Appeal Decision

Appeal Ref: APP/C3105/W/16/3165654

The Pheasant Pluckers Inn, Street Through Burdrop, Burdrop, OX15 5RQ

- The appeal is made under section 78 of the Town and Country Planning Act 1990 against a refusal to grant planning permission.
 - The appeal is made by Mr Geoffrey Richard Noquet against the decision of Cherwell District Council.
 - The application Ref 16/02030/F, dated 7 October 2016, was refused by notice dated 16 December 2016.
 - The development proposed is the erection of a single storey building providing three en suite letting rooms.
-

**PAPER SIZE : A4
SCALE 1: 100
REVISED ELEVATIONS**

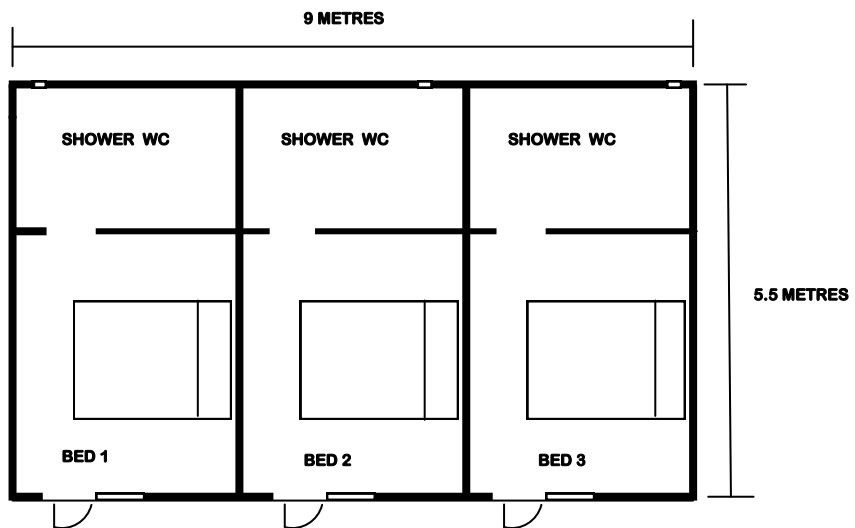
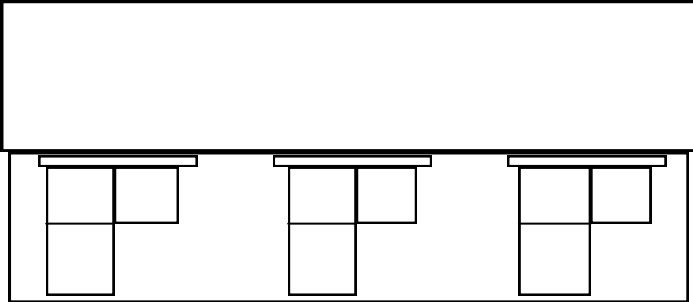
- way. The PH would still appear as a building on the edge of Burdrop slightly separate from the rest of the village.
11. The Council raised concern regarding the openings in the proposed building and I note revised elevations have been submitted, presumably to overcome this. These show only minor changes to the fenestration and are something which could be sought by means of a condition. No party would therefore be prejudiced by my considering this appeal on the basis of the amended plans.

12. On the street side three small slit openings are proposed in an otherwise blank elevation which would give it the appearance of a barn. This would fit with other traditional buildings in the area. There is a discrepancy between the revised floor plan and the revised elevations as to the exact position of these three openings but I find no harm with either and more detail in respect of these can be secured by condition. On the elevation facing into the car park would be doors and window openings evenly spaced, not unlike the arrangement found on a stables, which would not look inappropriate on an ancillary type building. In terms of the materials proposed the building would be constructed of local stone and would have a slate roof which would fit with the architectural vernacular of the area. I therefore find the appearance of the building to be acceptable.

19. I have undertaken some minor editing and rationalisation of the conditions proposed by the Council in the interests of precision and clarity. In addition to the standard time limit condition I have included a plans condition as this provides certainty. To ensure a satisfactory appearance I have also included conditions concerning the materials to be used, details of the doors and windows, and the colour of rainwater goods. However, it is not necessary for these conditions to be pre commencement. Nor is it necessary to seek revised elevations as the plans on which I have considered this appeal I have found to be satisfactory.
